Re: **US Eagle Credit Union - Academy**
5420 Academy Road NE
Traffic Circulation Layout
Engineer's Stamp 10-27-2021 (E18-D046)

Based upon the information provided in your submittal received 10-27-2021, the above referenced plan cannot be approved for Building Permit until the following comments are addressed:

C-100

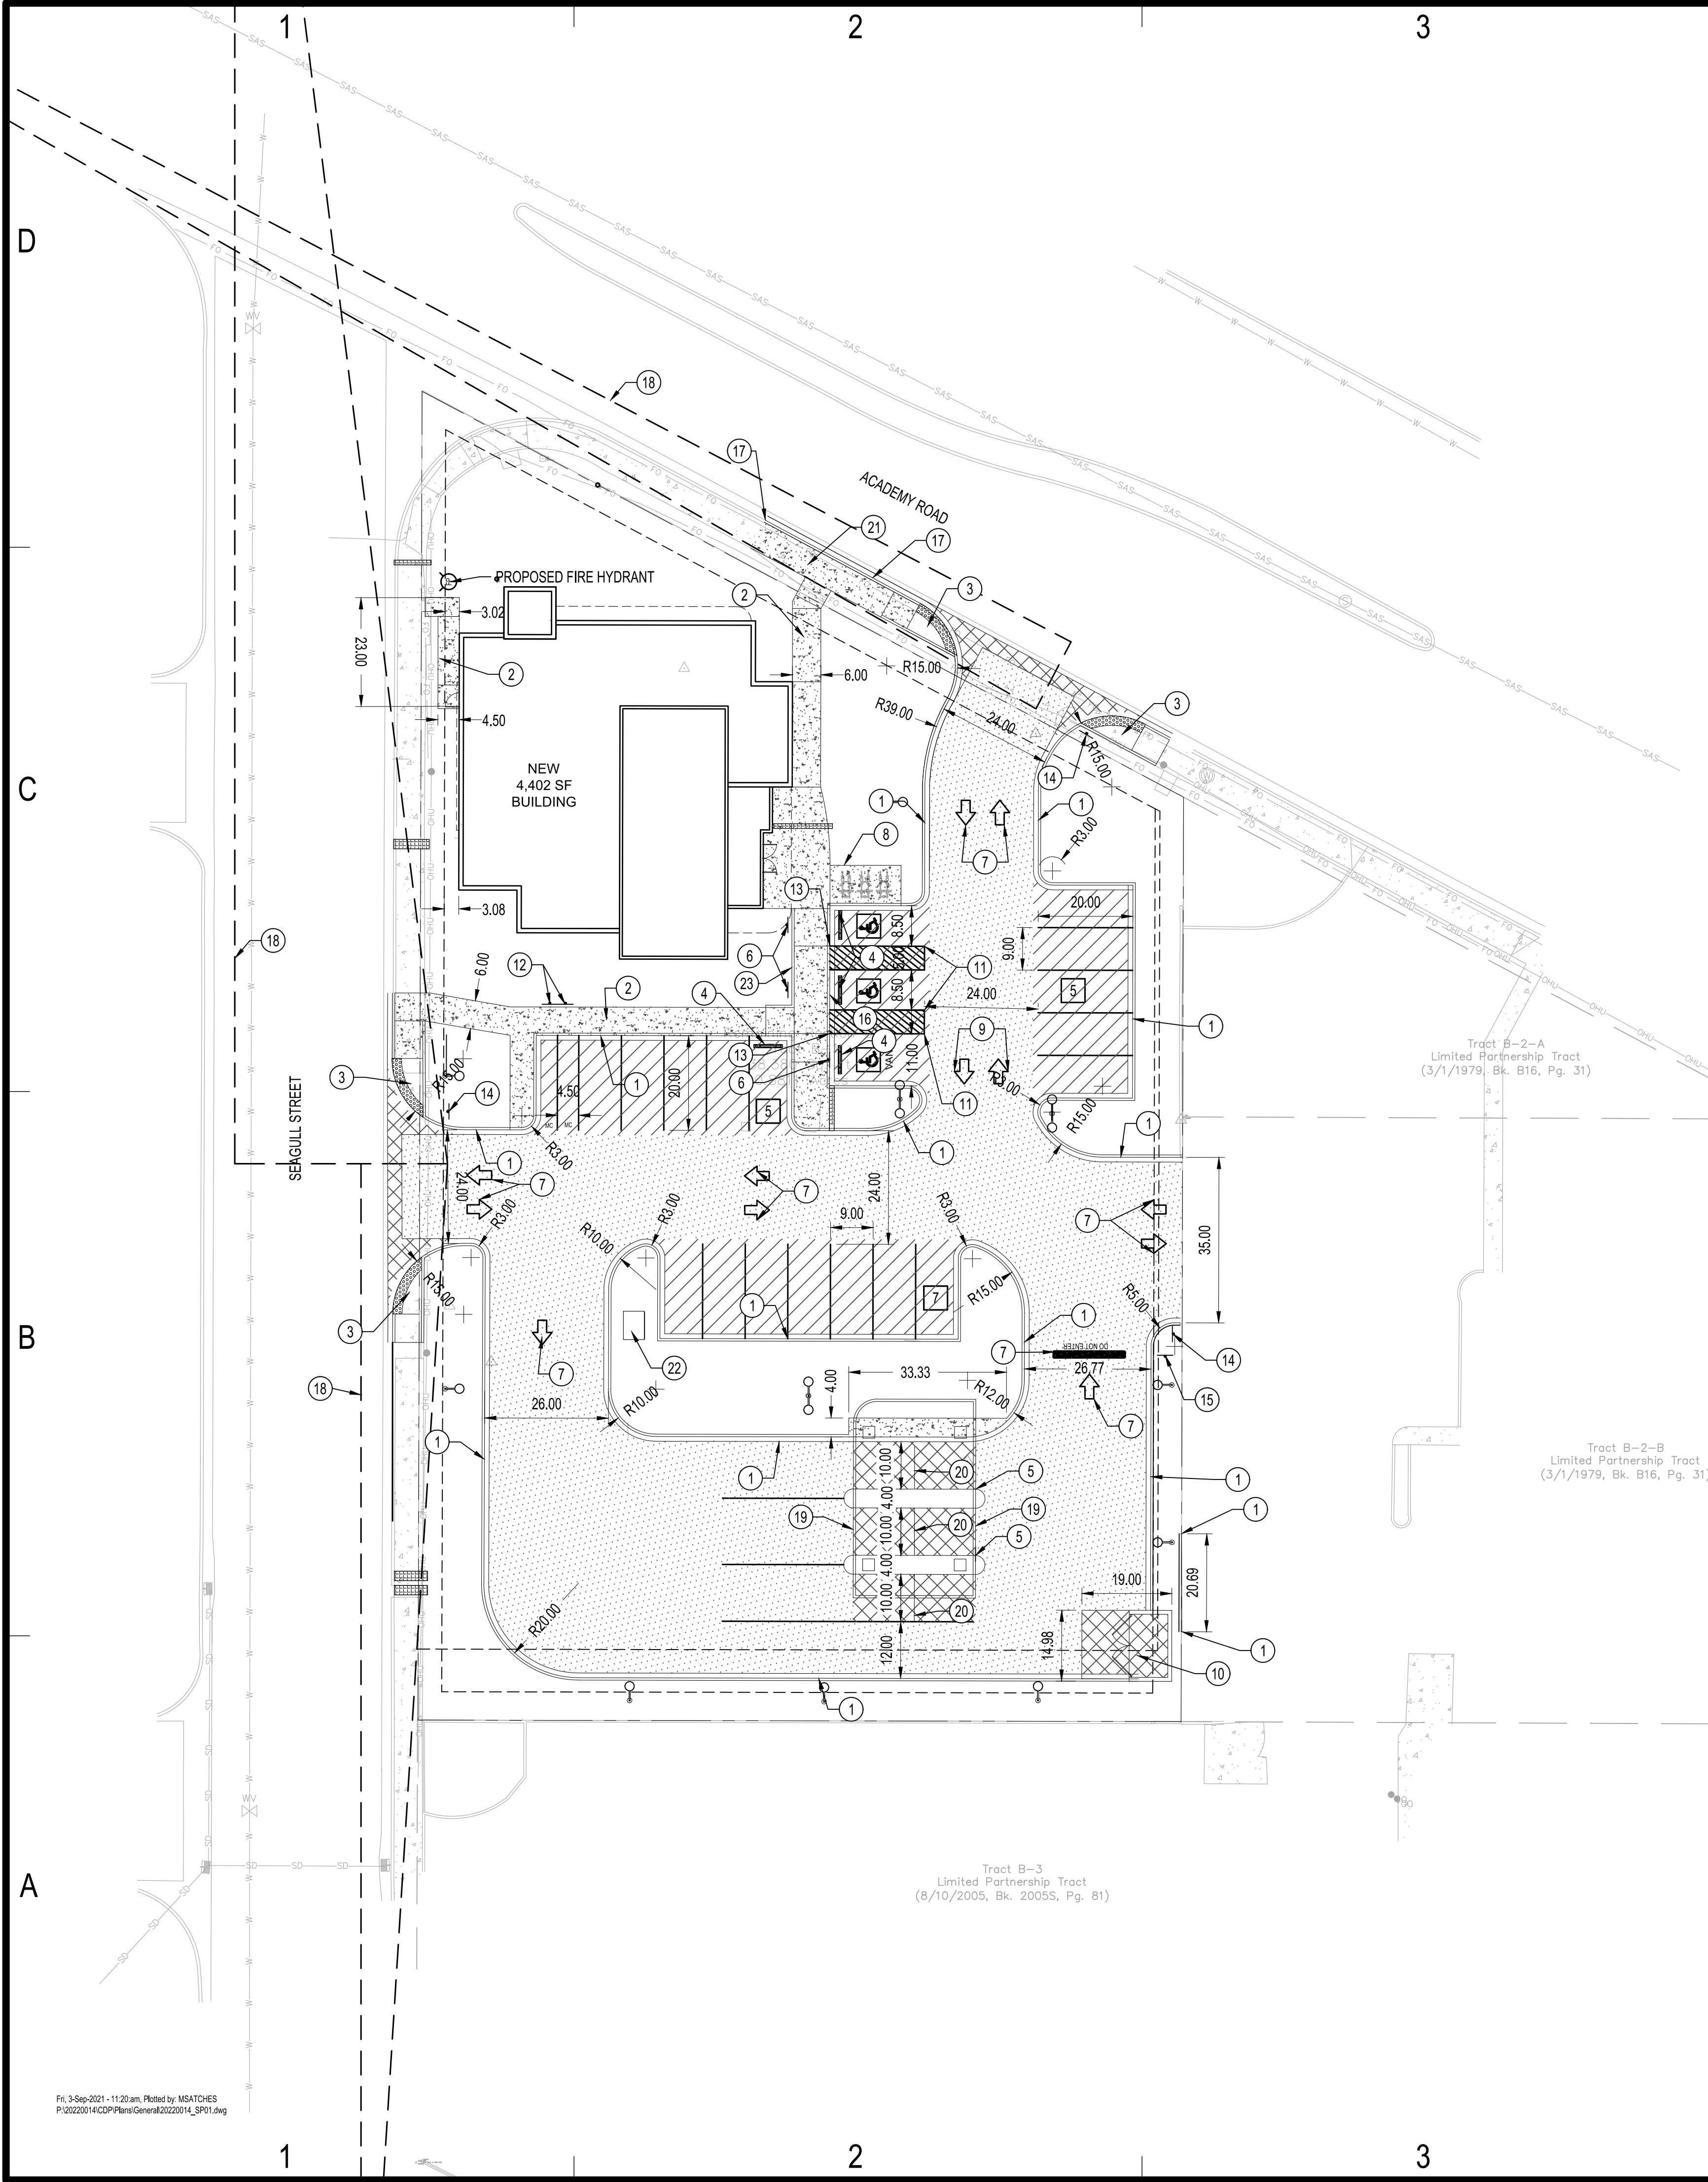
1. Academy/Seagull Corner:

- Existing Ramp: The ramp will need to be current/updated ADA and if it isn't then you will need to provide ramp and detail per COA std dwg

3. Keyed Note 7: please provide details for proposed pavement markings.

6. Per DPM, a 6 ft. wide ADA accessible pedestrian pathway is required from the ADA parking stall access aisles to the building entrances. Please verify 6ft width of pathway is provided with 5 ft width access aisle and not in conflict with parking bumper.

7. Key note 18: please provide details (dimensions).

8. Provide the width for the parking stalls that located at the Southside of the building.

9. Provide the length for the parking stalls that located at the Northside of the drive up Kiosk.

REVISED PARKING SPACES AND
30 FOOT ACCESS EASEMENT
WITHIN
TRACTS B-2-A AND B-2-B
LIMITED PARTNERSHIP TRACT
ALBUQUERQUE, NEW MEXICO

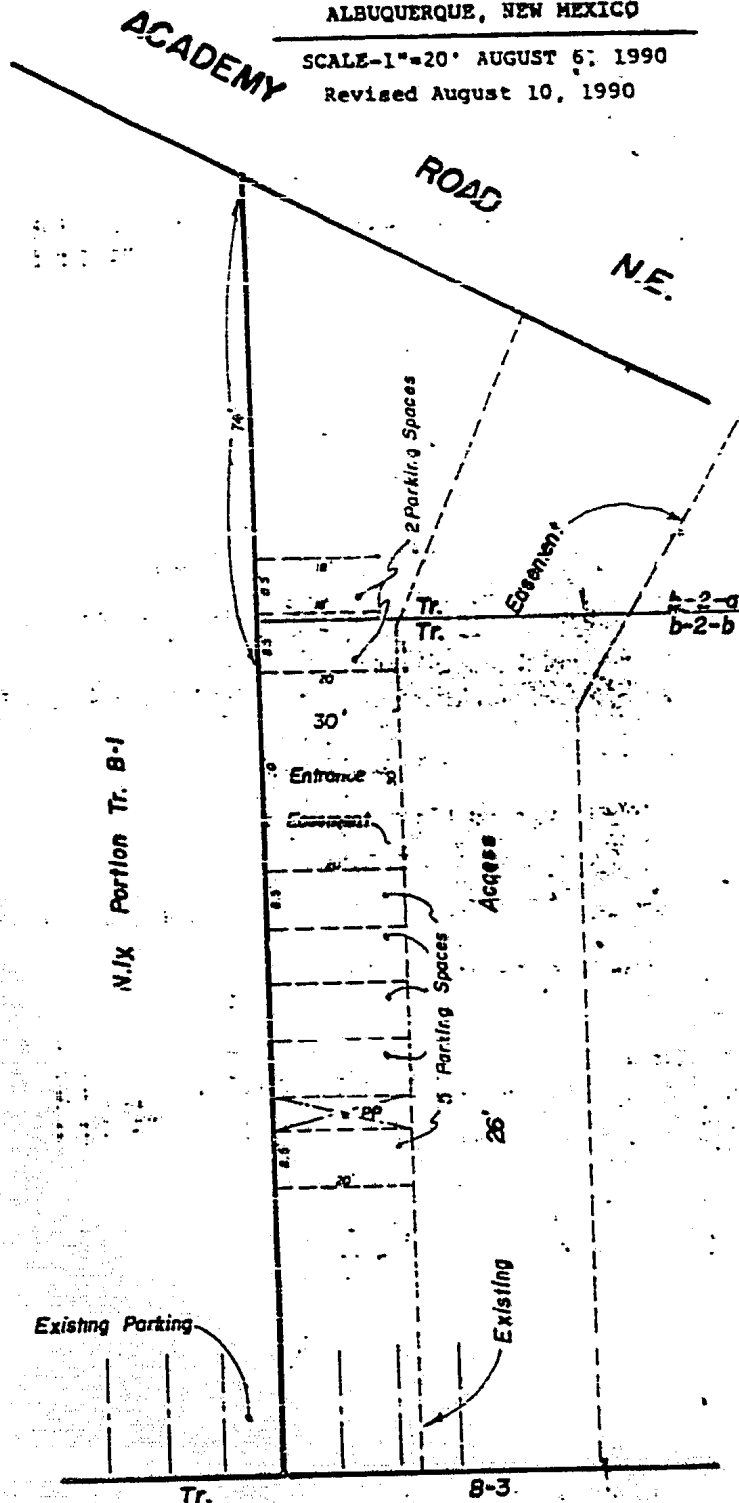
10. Shared Site access: driveways that straddle property lines, or are entirely on one property but are to be used by another property, shall have an access easement. Please include a copy of your shared access agreement with the adjacent property owner.

**9 WHEEL CHAIR RAMP DETAIL**

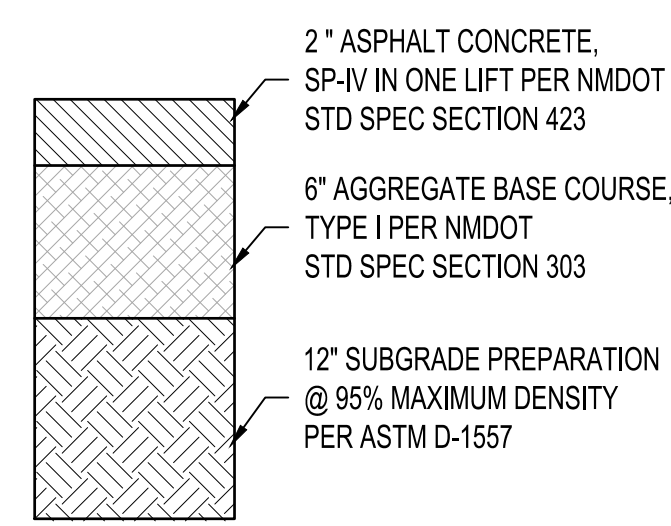
2. Keyed Note 3 (Detail 9 Sheet C-101): Add/reference COA std dwg 2426 or 2446.

**10 TYPICAL ACCESSIBLE PARKING SPACE**

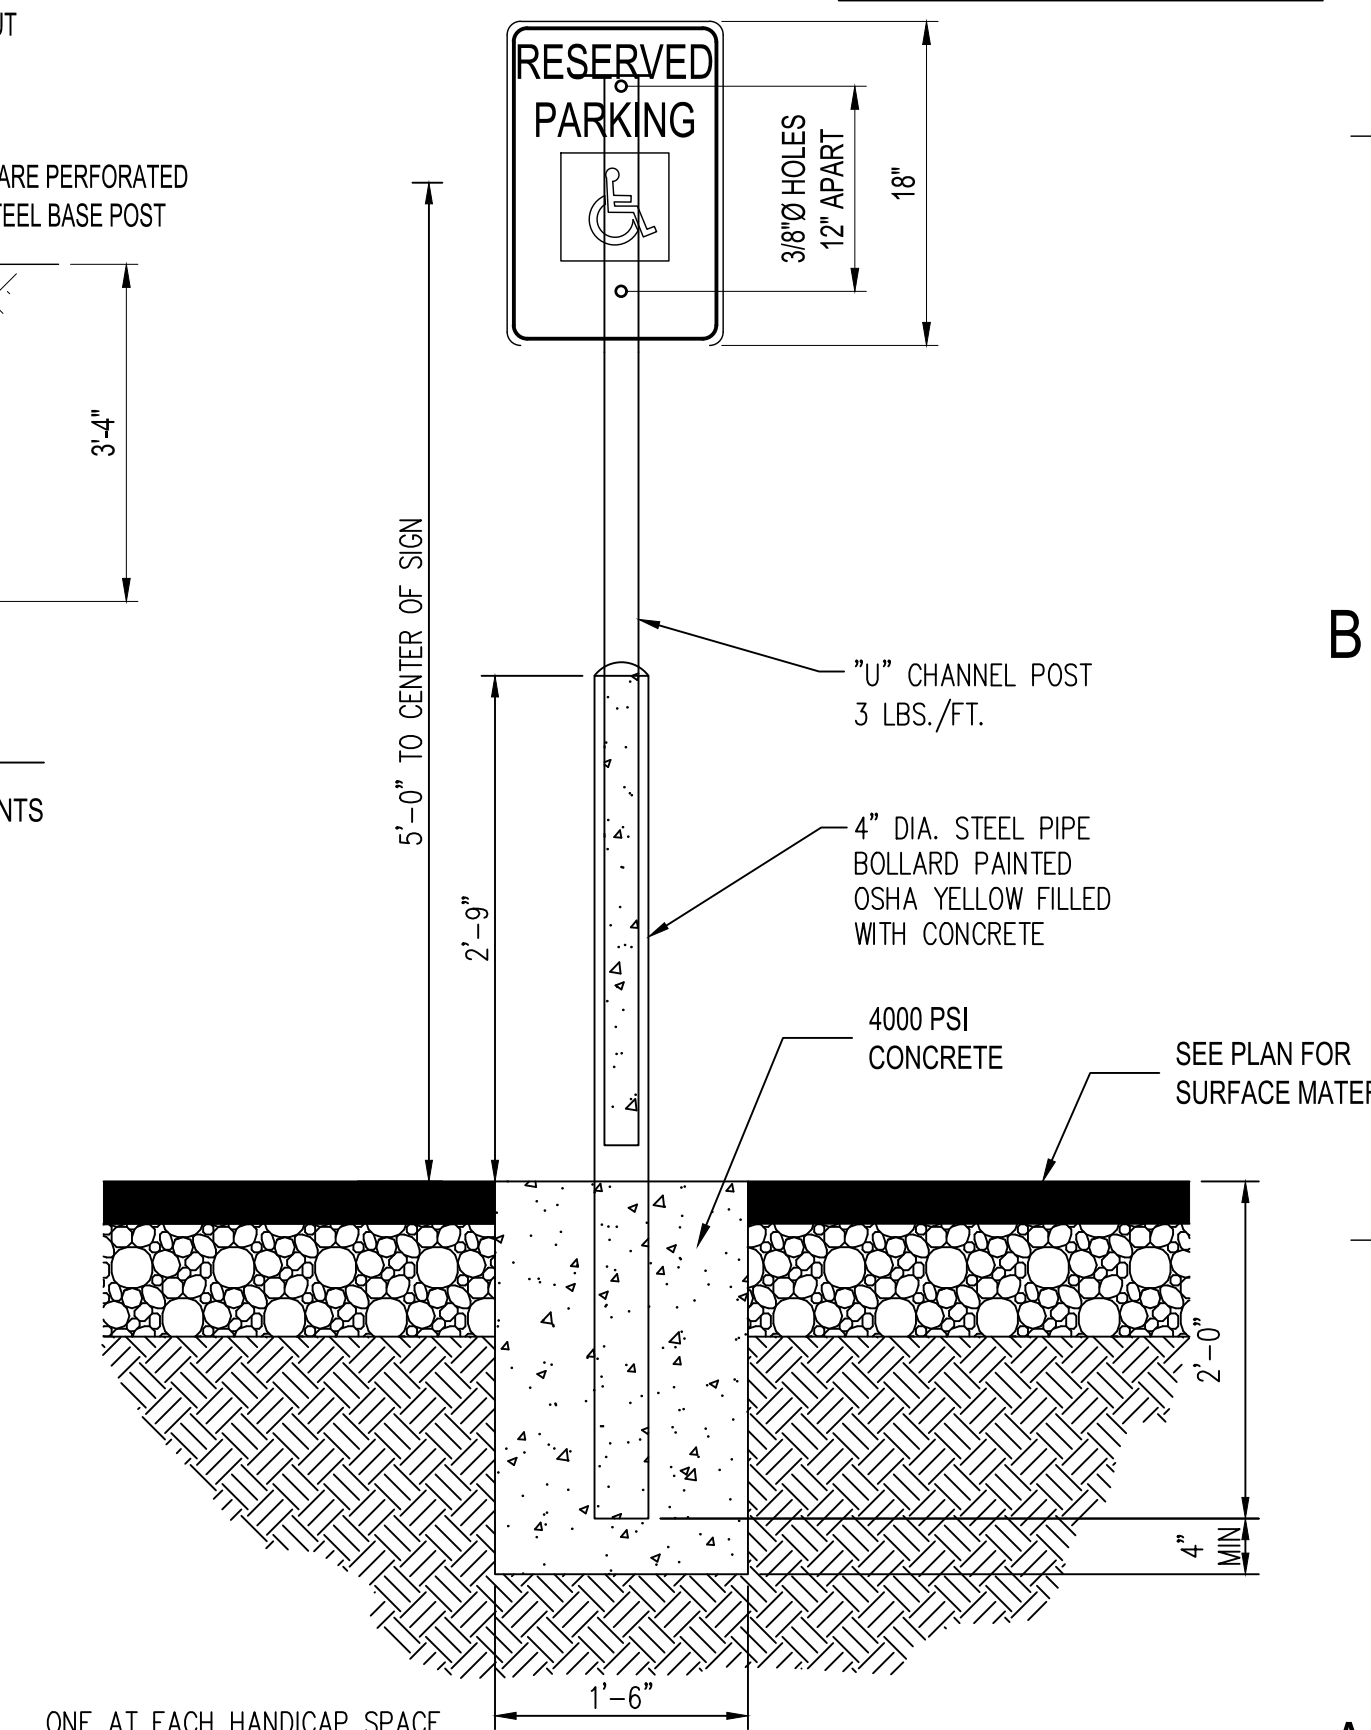
5. The ADA access aisles shall have the words "NO PARKING" in capital letters, each of which shall be at least one foot high and at least two inches wide, placed at the rear of the parking space so as to be close to where an adjacent vehicle's rear tire would be placed.
